1 Thompson's Pt., BP# 2017-01594 ice rink and accessory structures

I am in review of the permit for this year's ice rinks and accessory structures at Thompson's Point. Previously I was in contact with Soleil for the summer concert series and the following is a summary of the items that he and I discussed, and I sent in an email, that needed to be addressed prior to this next round of seasonal permits. Also, please see the attached files with comments requesting additional information for review.

Exhibit - B1 Power Distribution

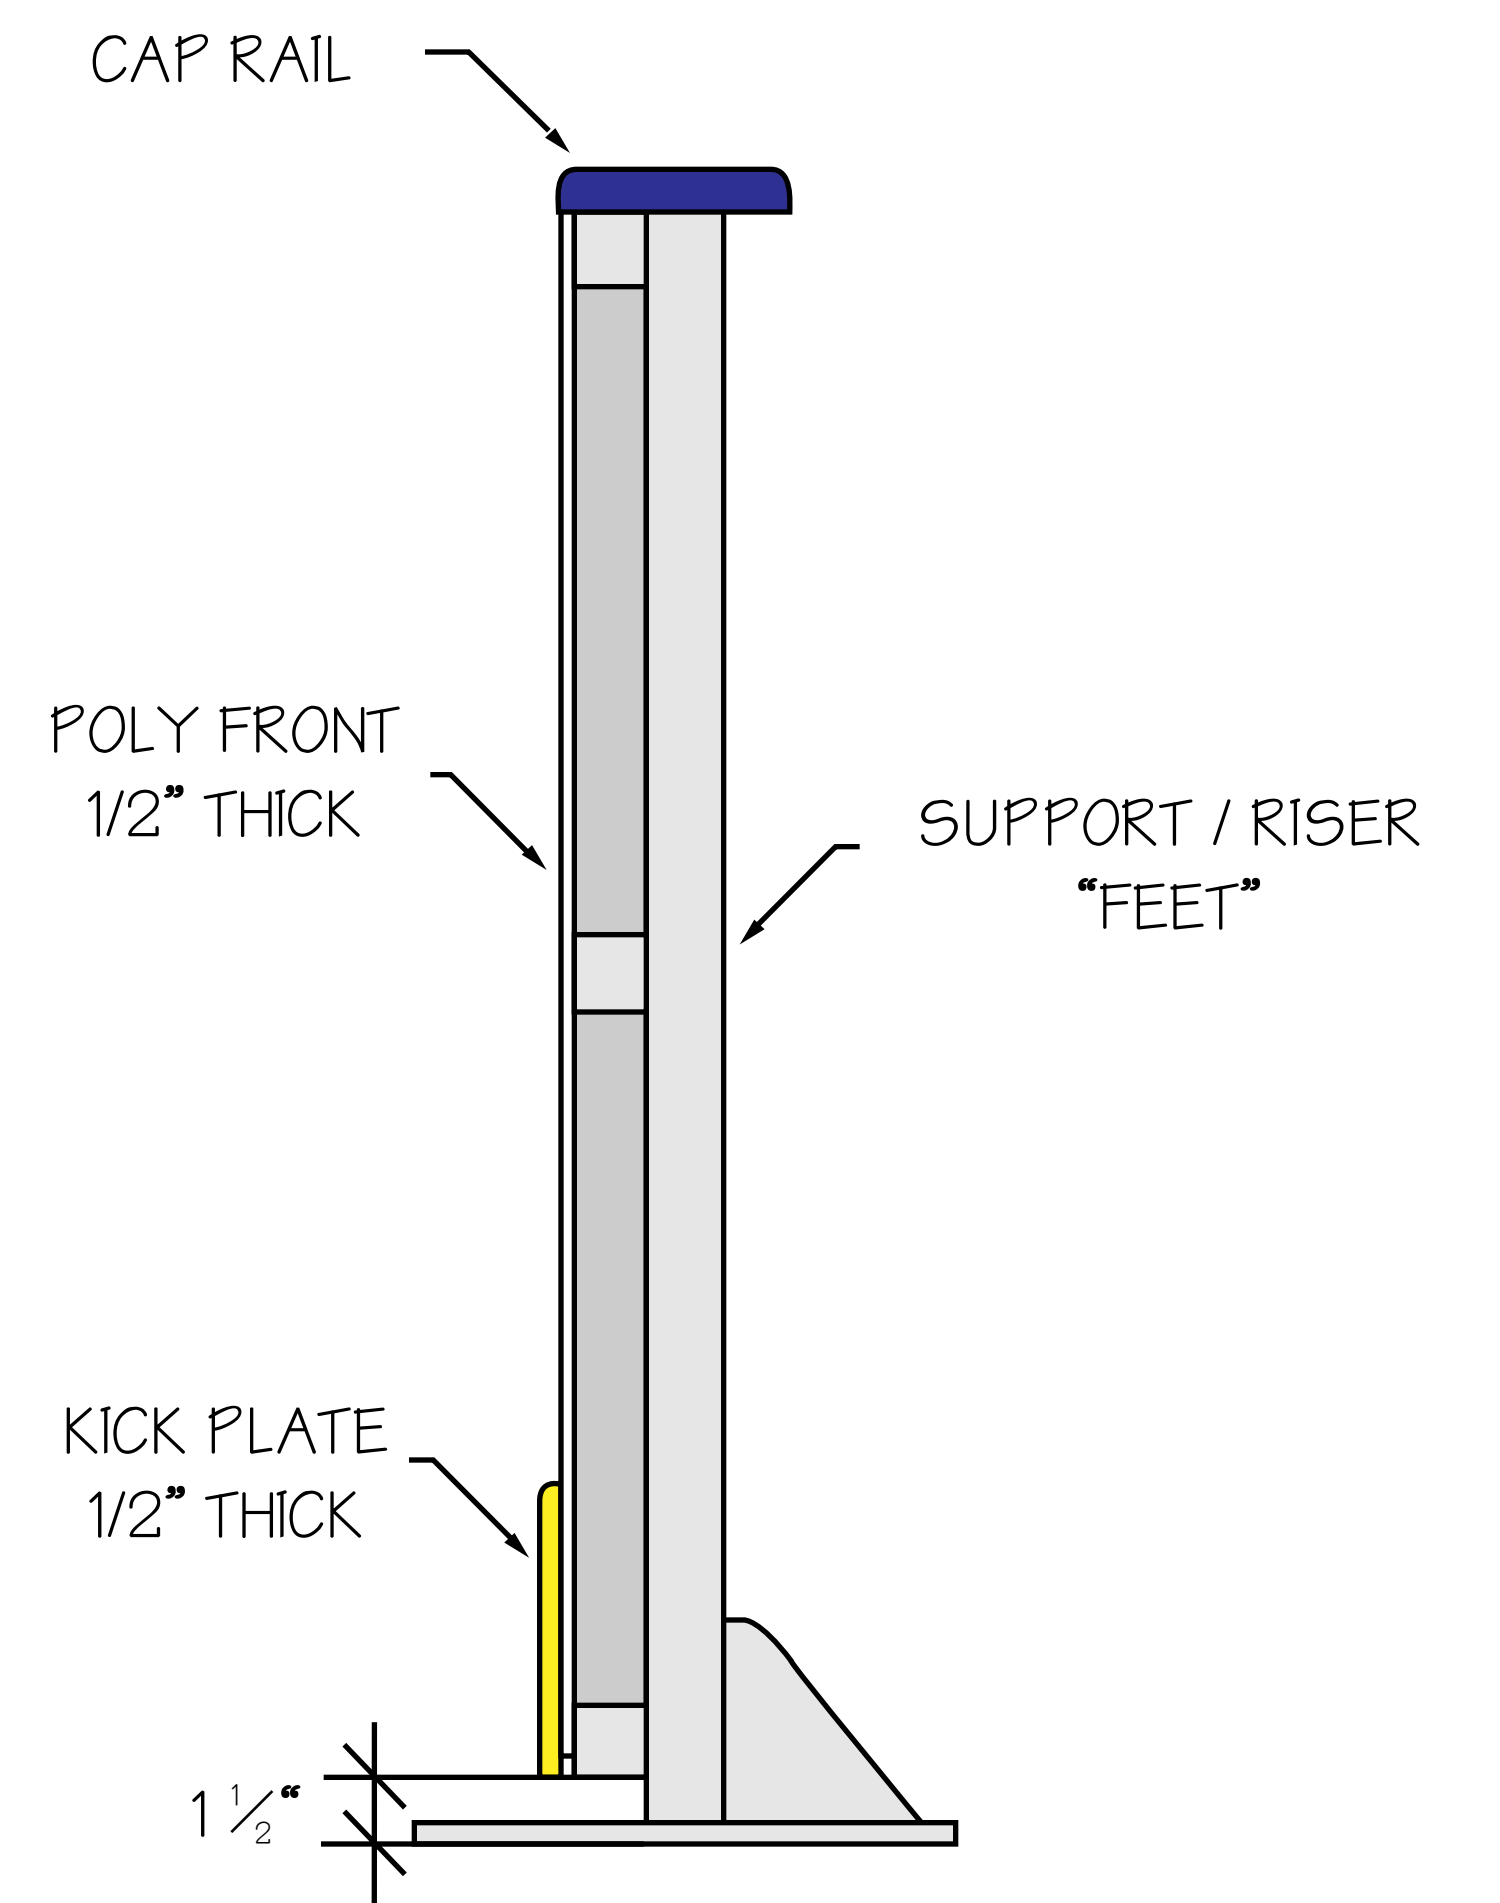
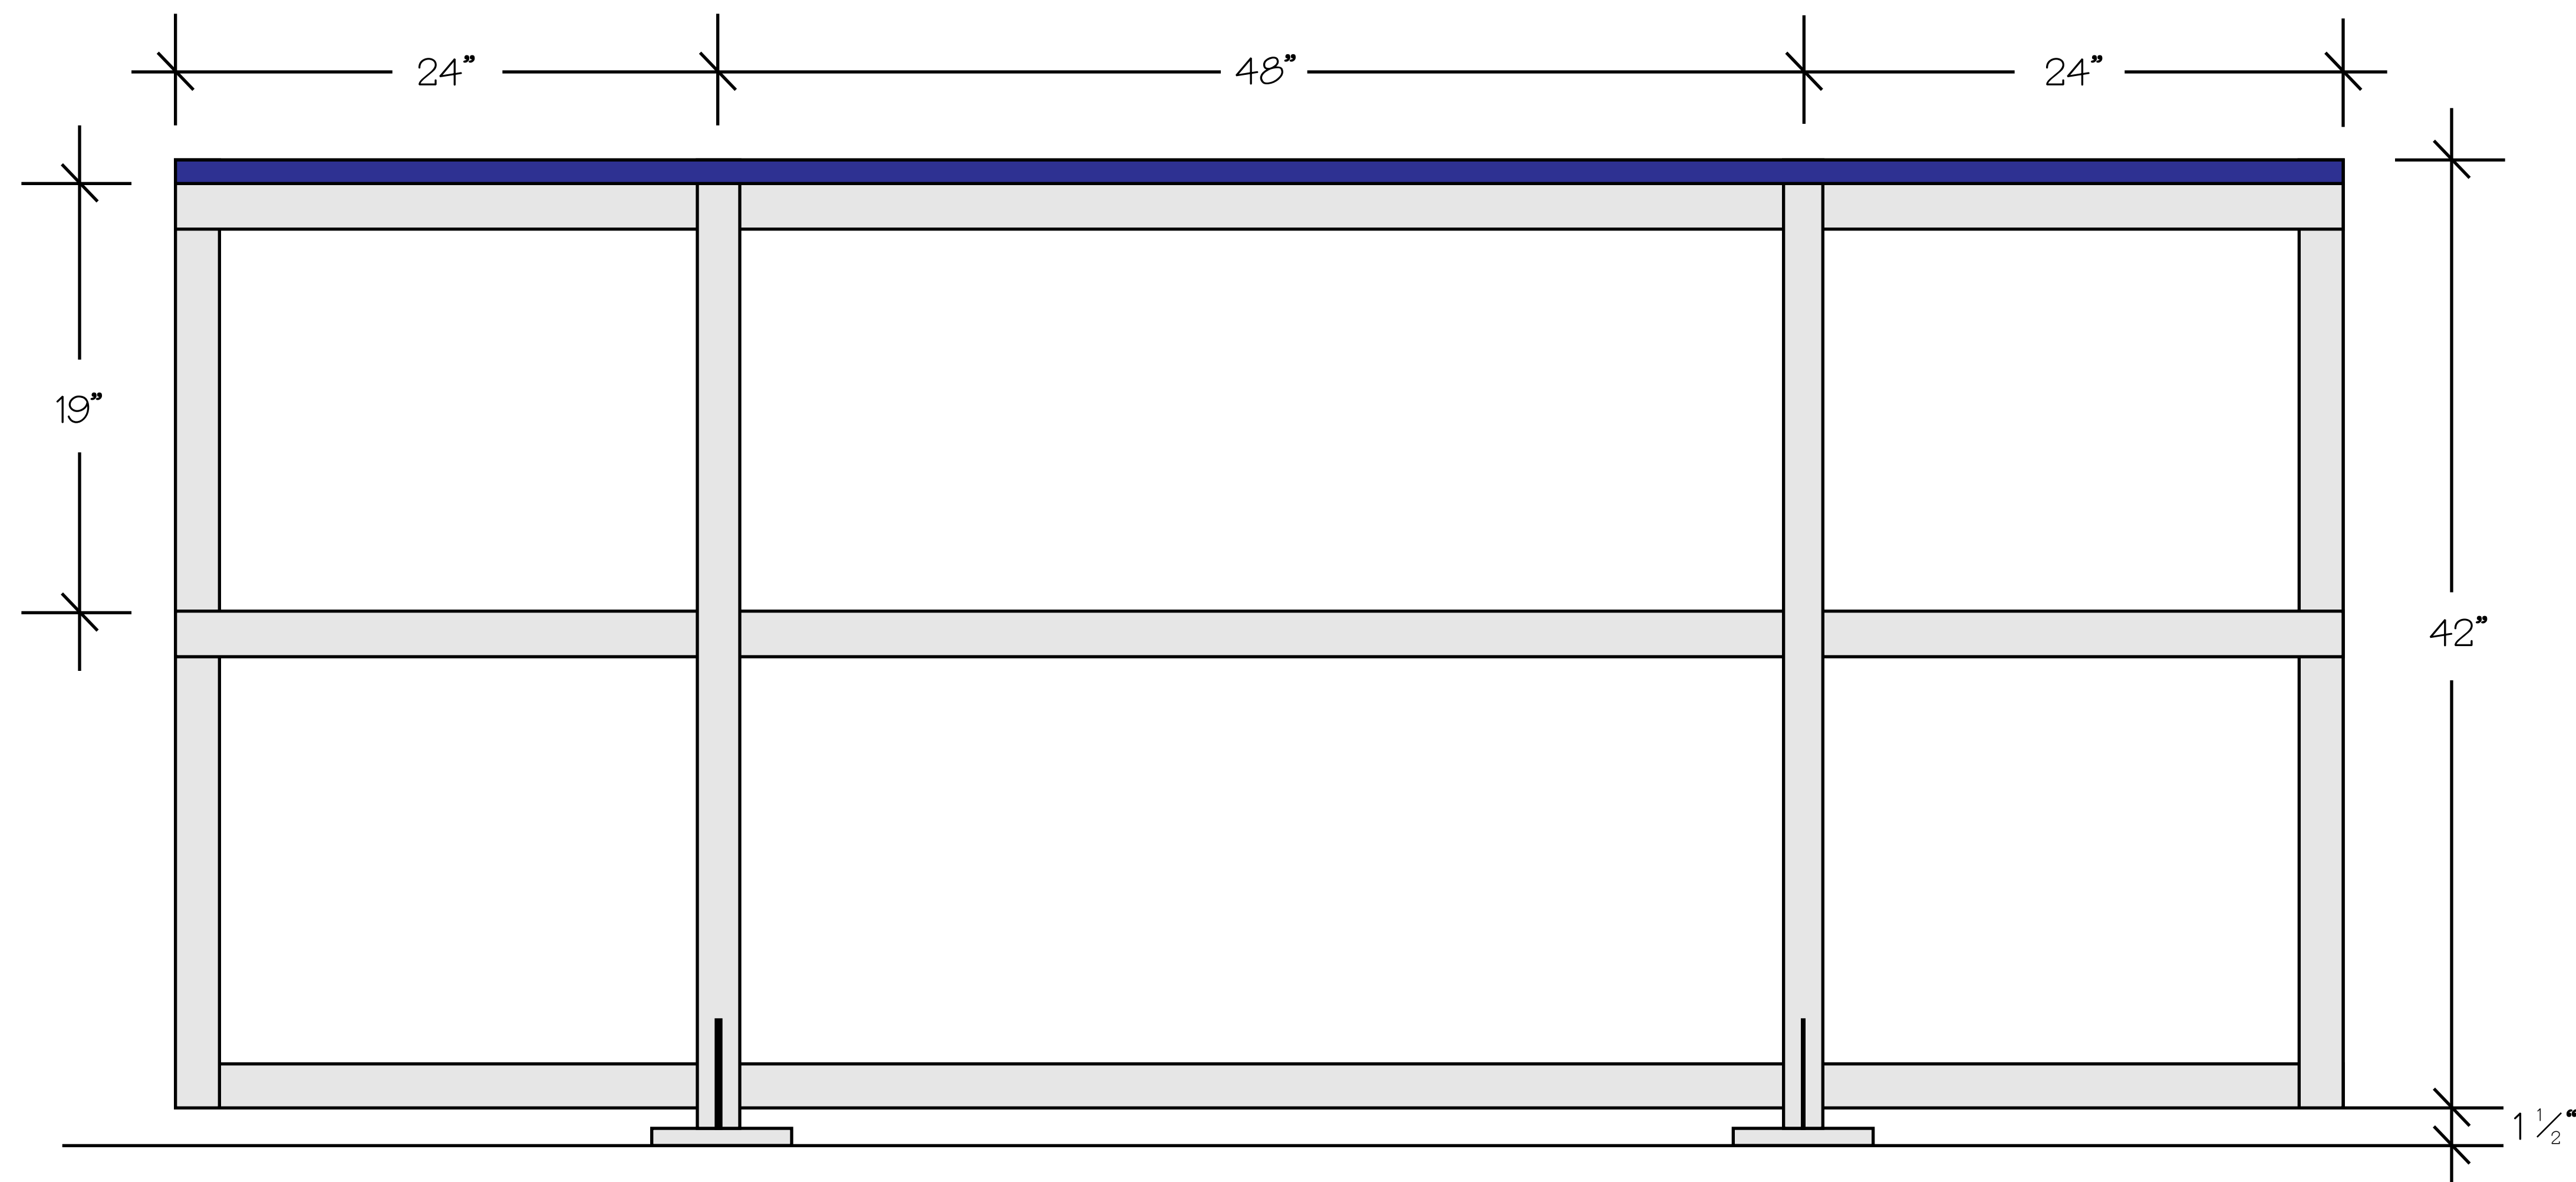
We had initially intended to pursue a panel upgrade to add the 600A service but the timing will not make it possible to do so for this season, so we will not be making that addition. Please let me know if you would like us to modify this exhibit and resubmit.

1. We have all the pages in the B7 VIP container file except for Plan S1.1. Please send this as a separate pdf file, and note, the scanned copy is not legible, hopefully you have an original file in your records.

As requested, I have updated the Power Supply Distribution, is it attached as B1- Power Distribution Updated.

ICE RESURFACER STRUCTURE  
FRAMING / ROOF

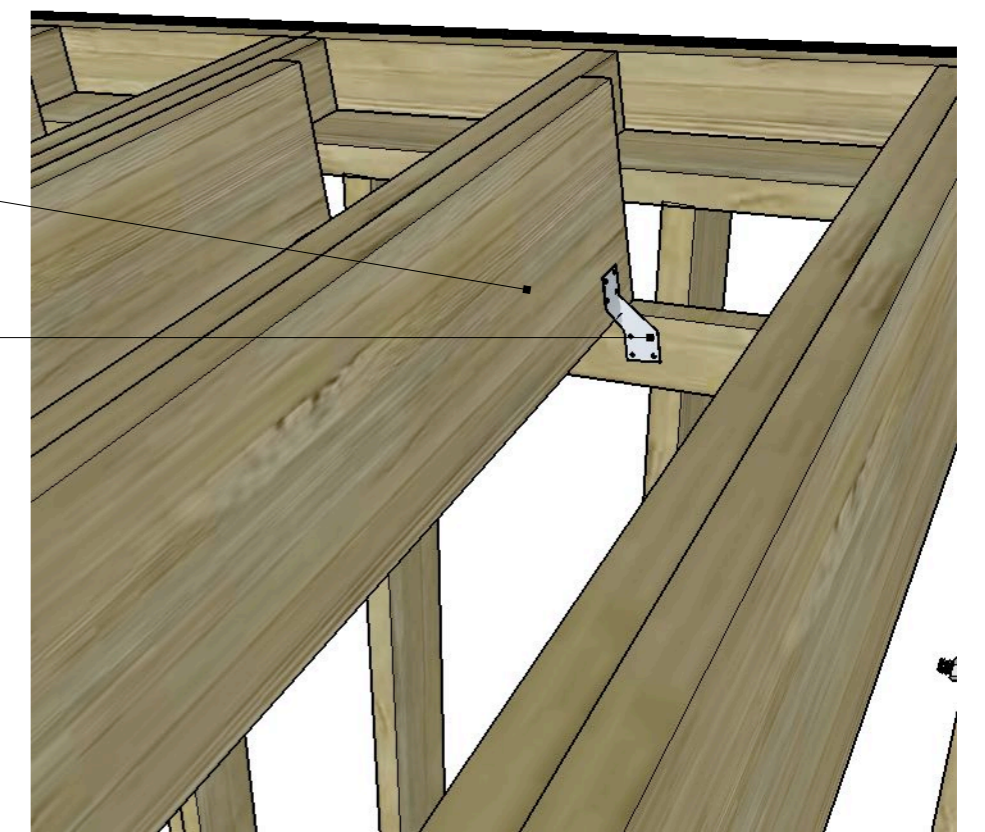
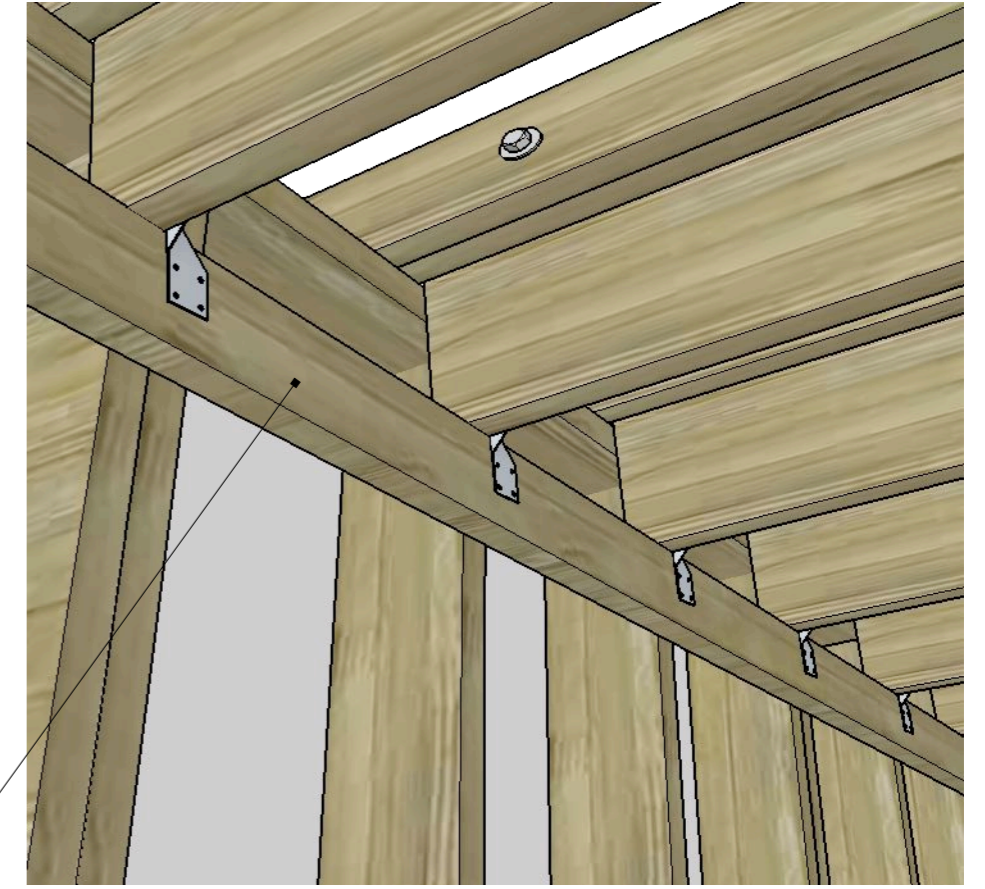
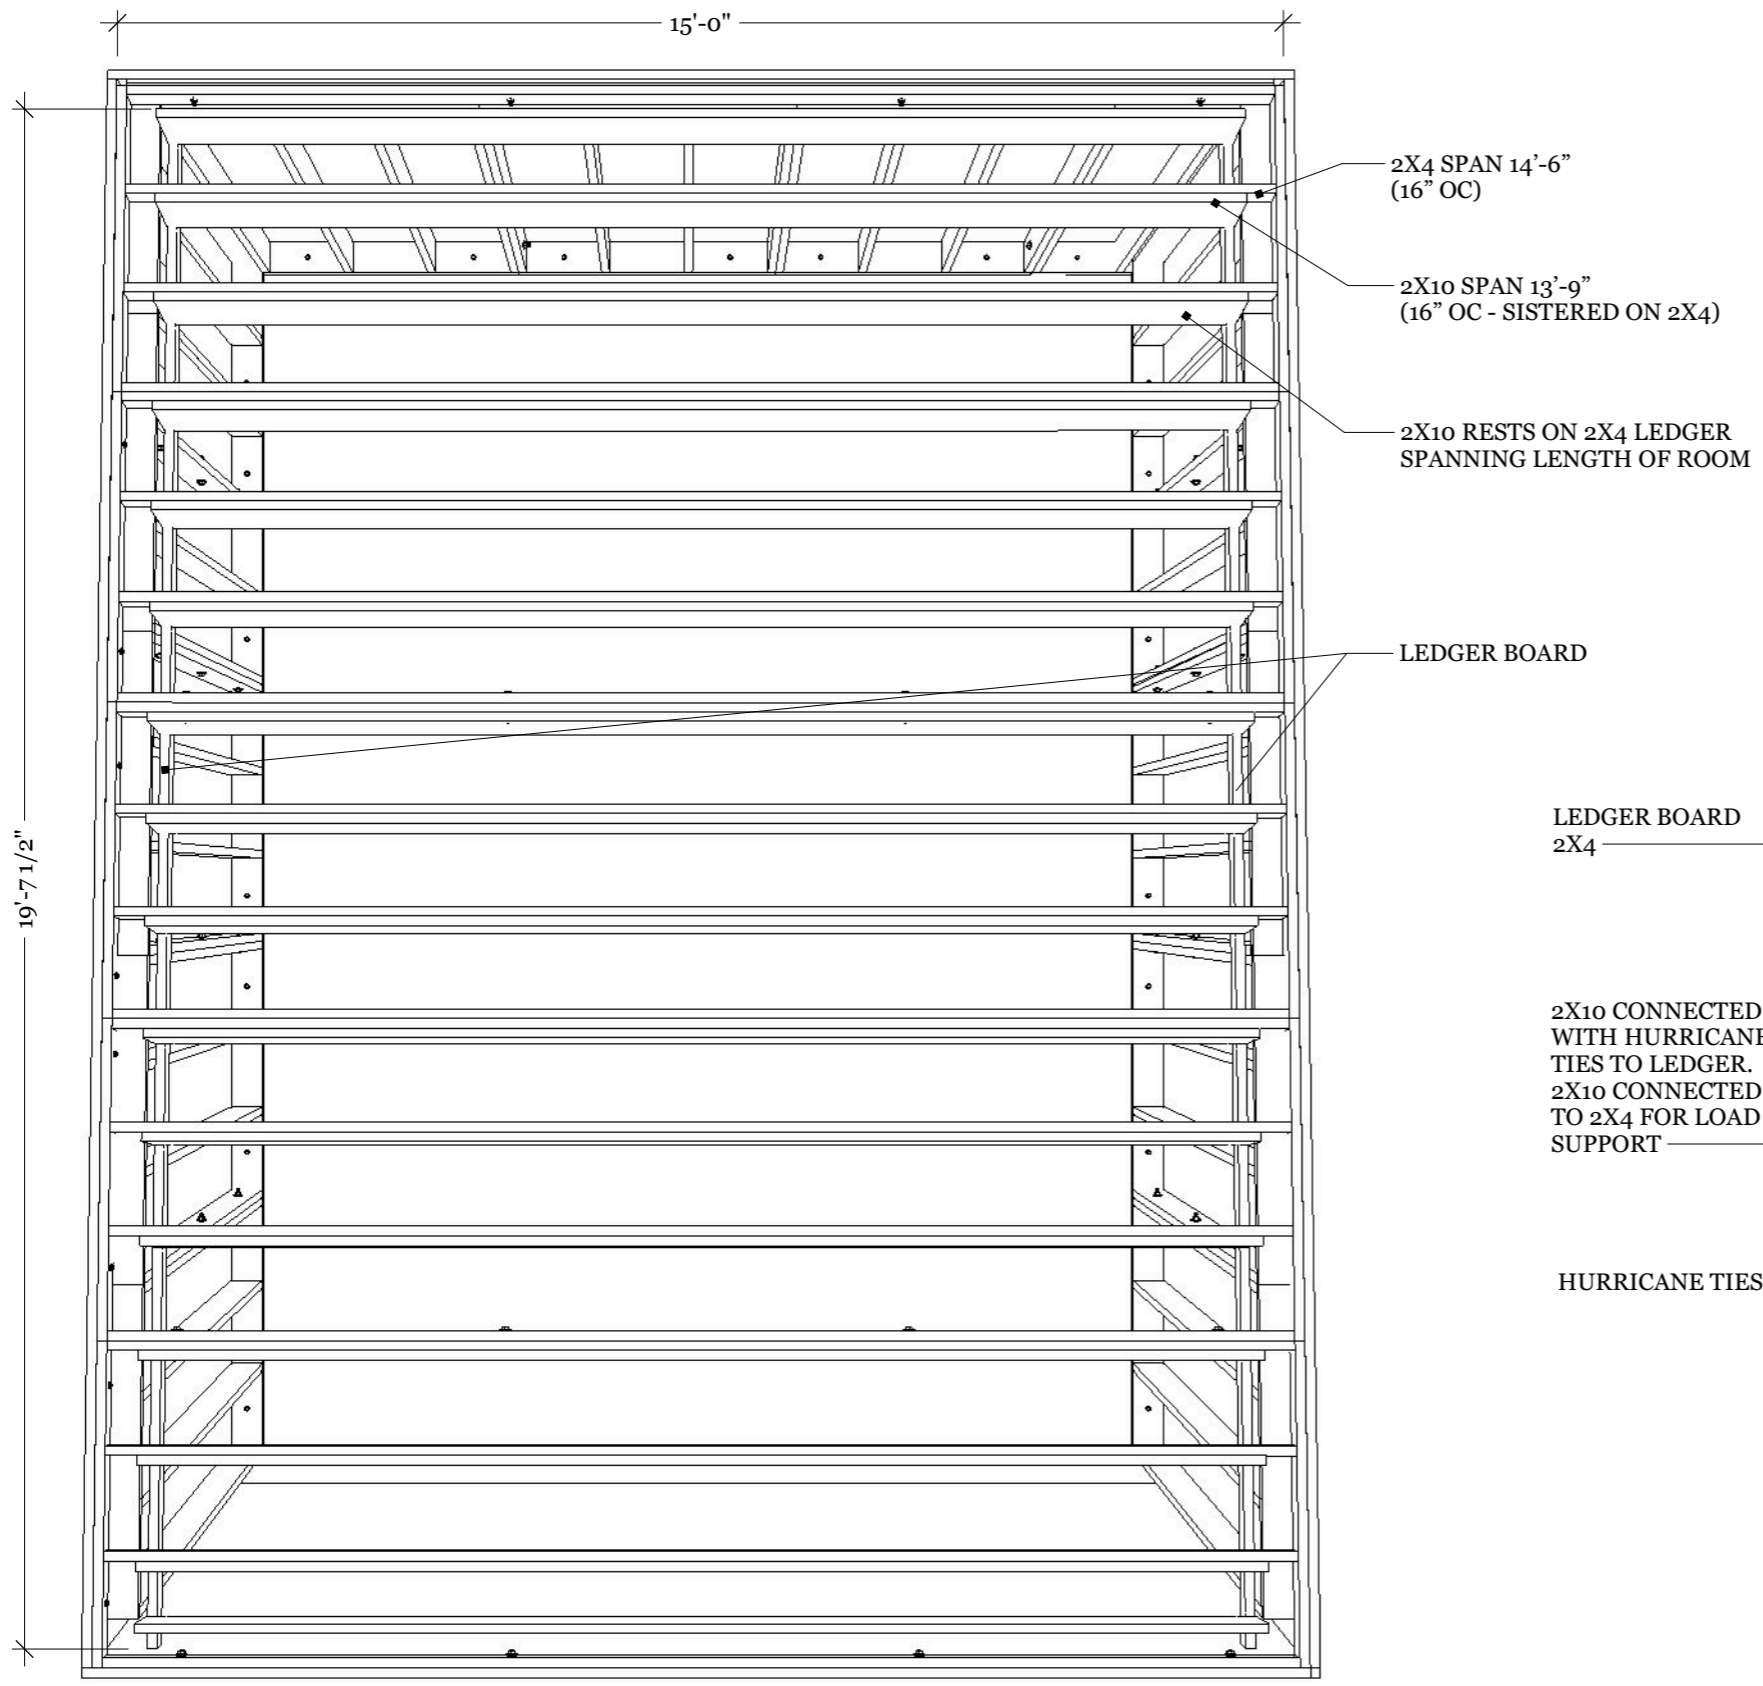
We will submit this additional information for the temporary equipment garage under separate cover immediately. Also thank you for flagging the incorrect dimension listed in our letter.

The rafter and snow load information in regards to the Garage has been requested from Iceops. I will forward as soon as it is received.

There is no heat source as it is insulated with Rigid Foam Board R-32.

The attached shows the rafter construction as requested.
